**Consultation Response from KC,  
Highways Development Management**

**2023/92821 Pentlands, New Mill Road, Holmfirth, HD9 7LN**

**Discharge of conditions 3 (CMP), 10 (Arboricultural Method Statement), 16 (traffic noise), 19 (external facing and roofing materials) and 21 (CEMP: Biodiversity) of previous permission 2020/91896 for demolition of existing dwelling and erection of 15 dwellings with associated access and external works**

**Date Responded: 9-10-2023.**

**Sight Lines - 2.4m x 70m**

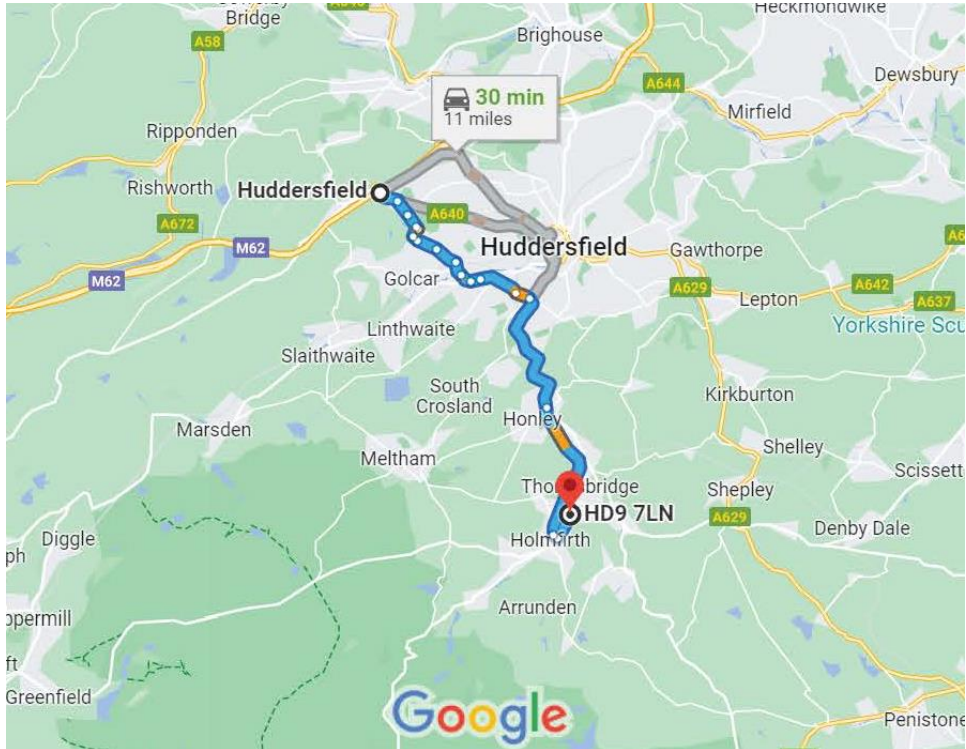
1, No details of sight lines from the proposed construction access on to New Mill Road are provided. 2.4m x 70m should be shown to be provided.

**Access Route to Pentlands from M62**

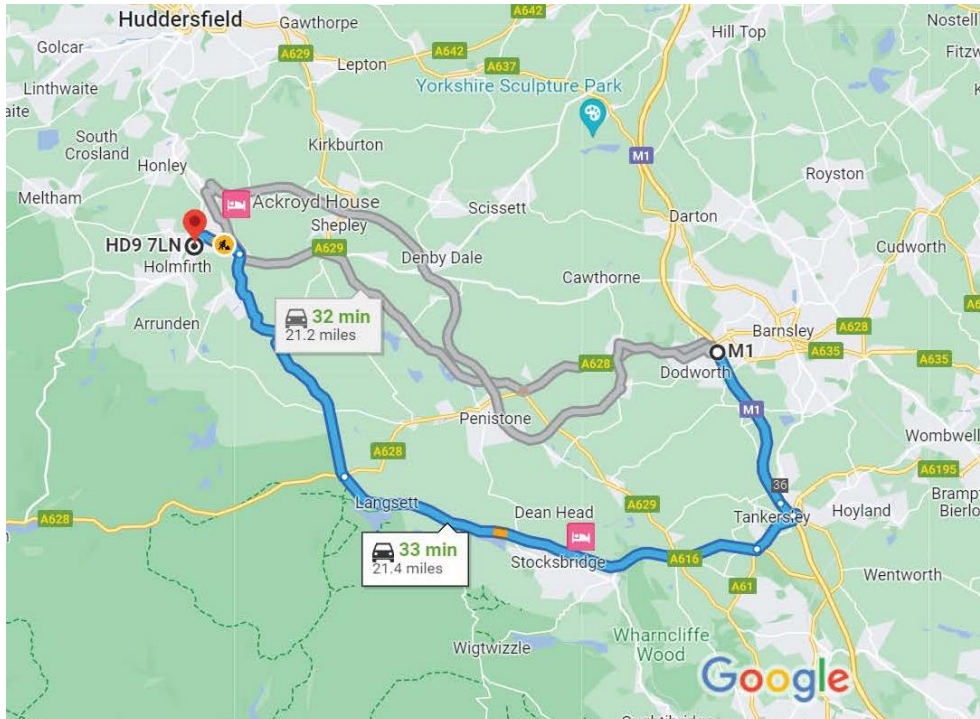
3, No HGV vehicle routes are provided.
